Application by Highways England for an Order Granting Development Consent for the A38 Derby Junctions Scheme

Issue Specific Hearing 4: Wednesday 19th February 2020

Written Summary of Oral Contributions on Behalf of Derbyshire County Council

Little Eaton Junction Improvements

FIGURE 2.12F ENVIRONMENTAL MASTERPLAN (LITTLE EATON JUNCTION)

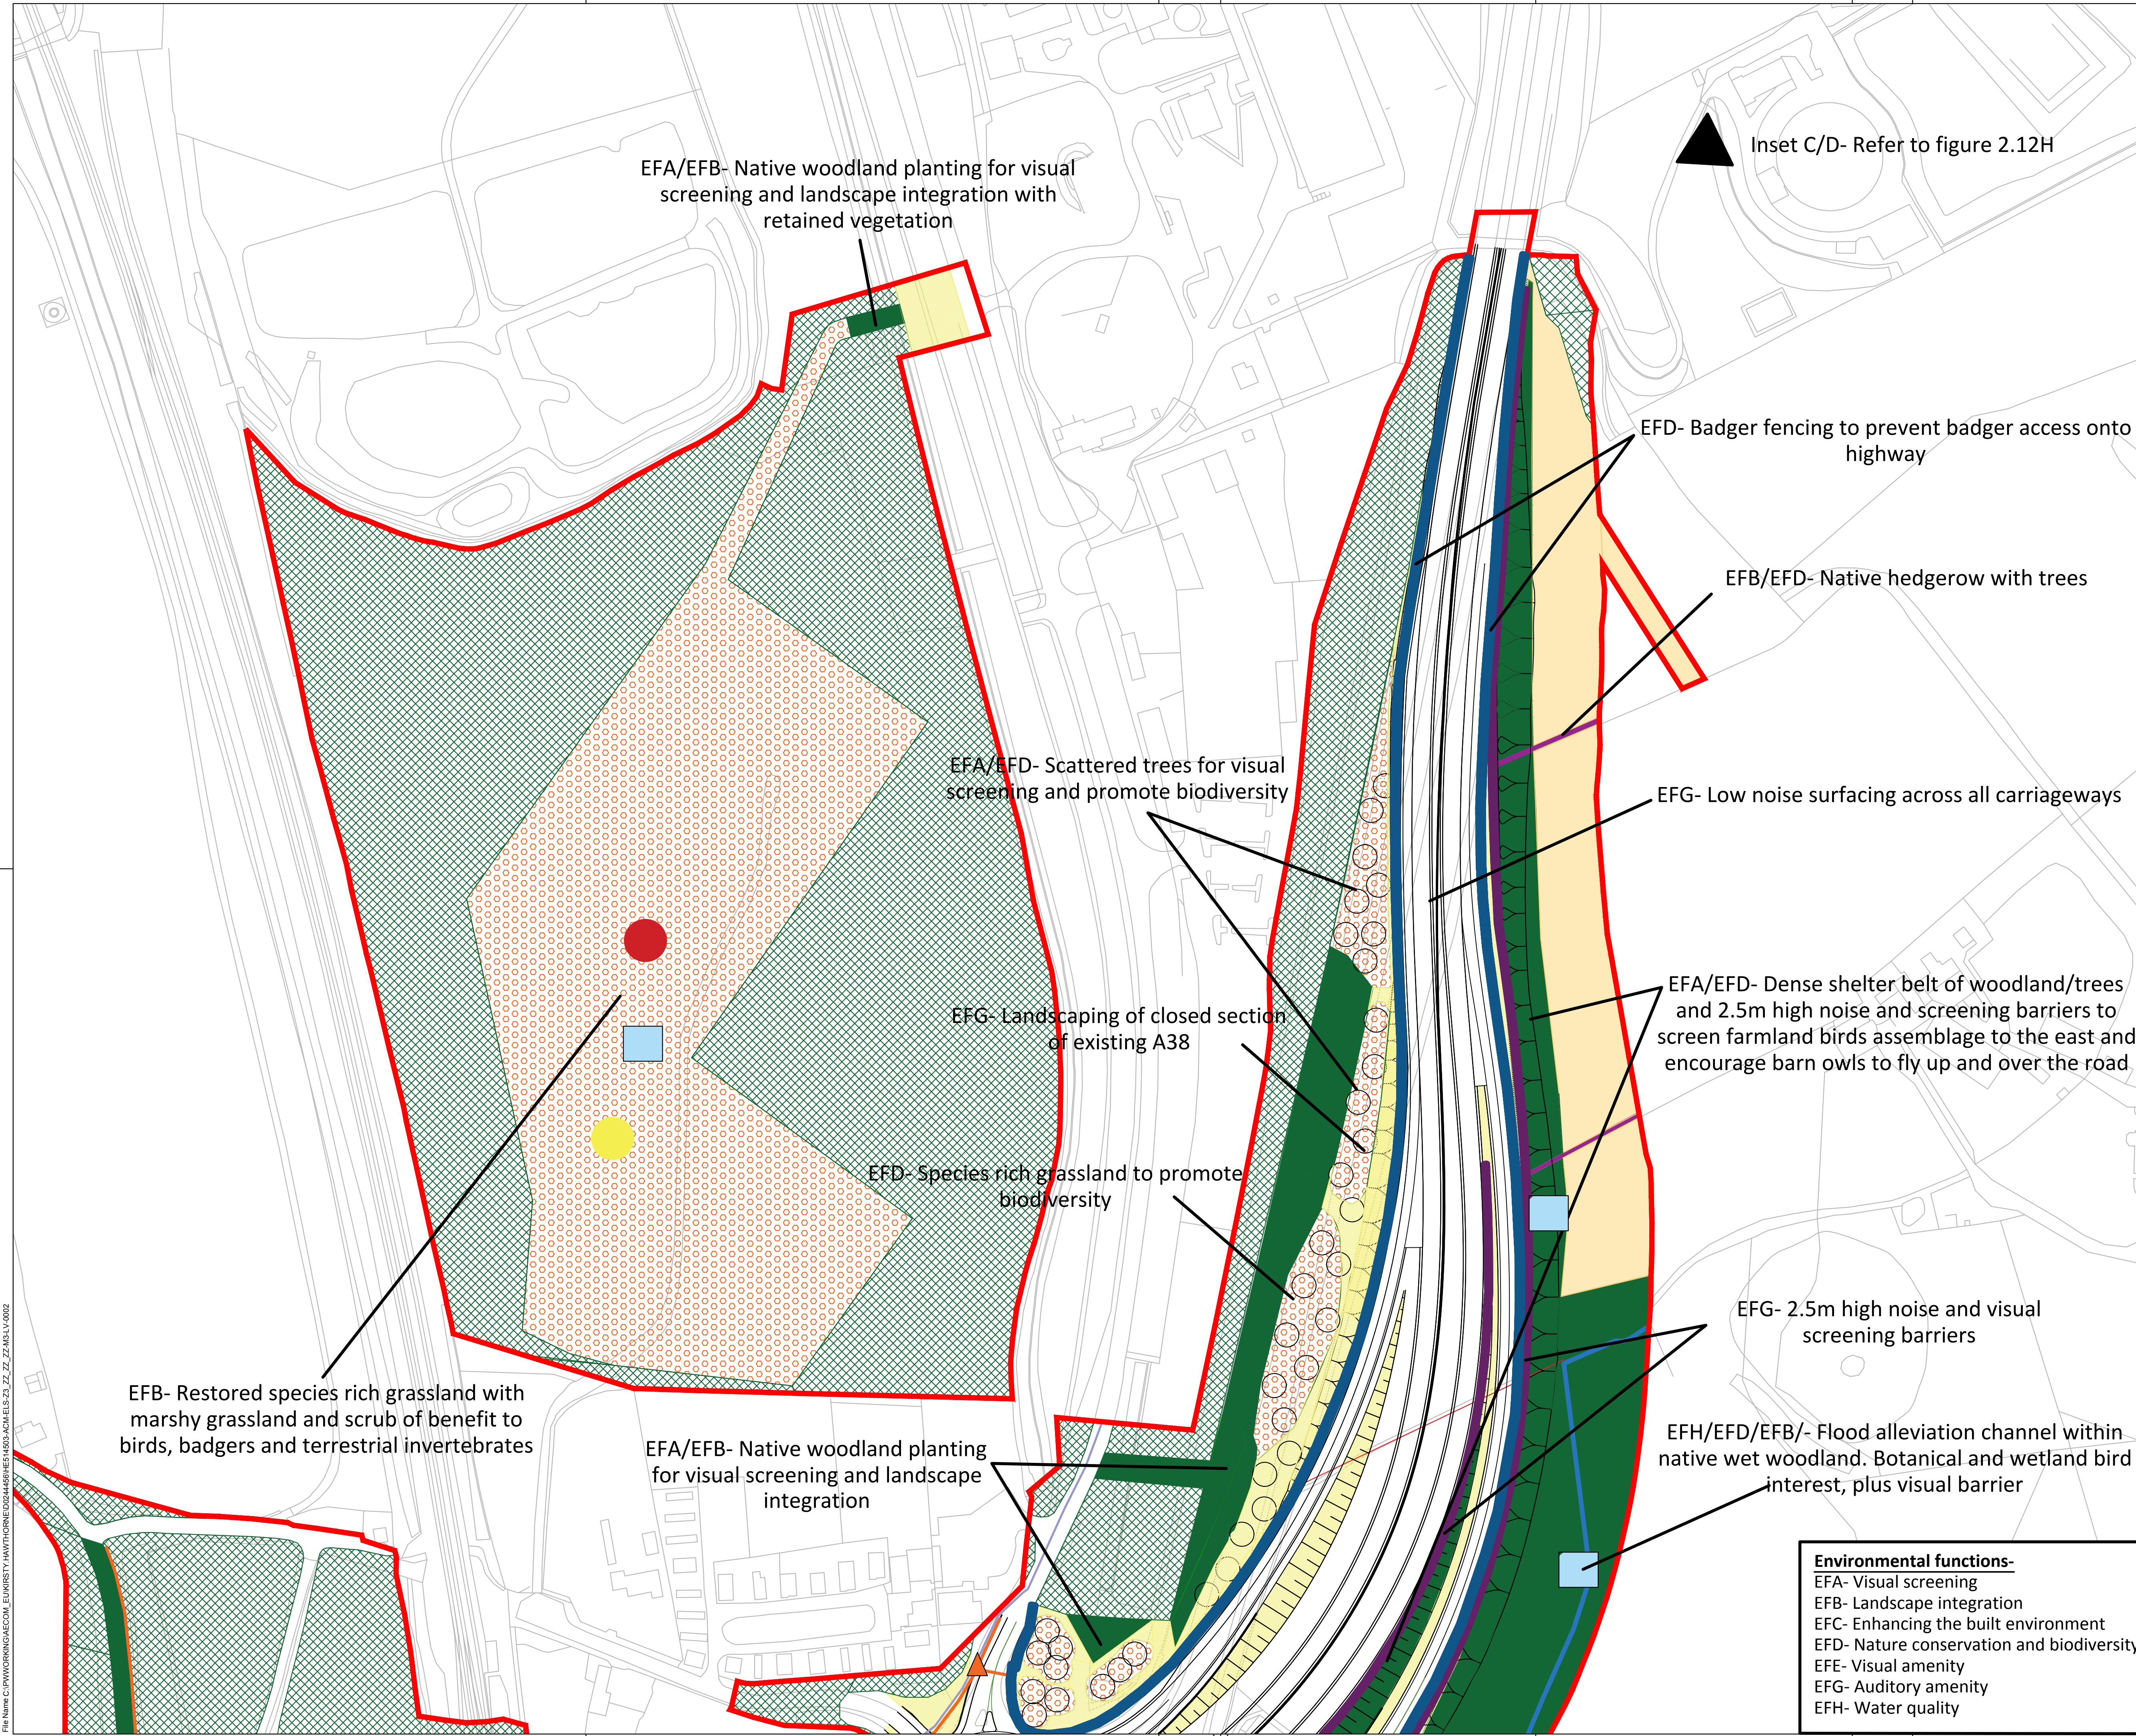
a) Footpath diversions at Little Eaton junction including the linkages between existing and proposed footpaths and the proposed diversion of FP3.	DCC indicated that the main outstanding issue with regard to the diversion of footpath diversion FP3 was in respect of the proposed provision of a new toucan crossing on the A61 to the south of where FP3 adjoined the A61 to the south of the new Little Eaton junction. A proposed detailed scheme had been designed by Highways England's consultants that had been submitted to DCC and was currently under consideration and assessment.

<p>From the point where FP3 adjoined the A61 to where the new toucan crossing was proposed was currently just unsurfaced highway verge and so from DCC's point of view, there was a need to ensure that this stretch of verge was surfaced to encourage pedestrians using diverted FP3 to walk southwards and cross the A61 via the new crossing. This issue was under consideration and discussion with Highways England.</p> <p>DCC indicated that there would be a need for the County Council to monitor the new 50 mph speed limit proposed for the stretch of highway from the new junction improvements southwards on to the A61 towards the proposed new toucan crossing point when the scheme was complete and operational. If 50 mph limit was unsuccessful in reducing traffic speeds on the stretch of the A61 then it may not be appropriate on safety grounds to provide the crossing as proposed. A decision would be taken by DCC once monitoring had taken place, which would be likely to be around three months.</p>

7) Landscape and Visual Impact	
a) Landscape tree planting at Little Eaton Junction	<p>DCC confirmed that the details of the tree planting scheme that had been submitted by the applicants at this stage of the DCO process for the Little</p>

<p>Eaton Junction part of the scheme were acceptable to the County Council. DCC was content that a greater level of detail would be submitted at the detailed design stage and that DCC would be consulted further at that stage in the DCO process for its comments.</p> <p>DCC emphasised that details of the tree planting scheme that had been submitted at this stage in the DCO process, particularly the photomontages that had been produced by Highways England's consultants, were very important in satisfactorily addressing DCC's concerns relating to the landscape and visual impacts of the scheme and in informing the Council's revised position that the impacts of the scheme on the openness of the Green Belt, Outstanding Universal Value of the Derwent Valley Mills World Heritage Site and landscape and landscape character of the area, were now considered to be acceptable with the tree planting mitigation proposals in place, particularly to the east of the Little Eaton junction.</p>
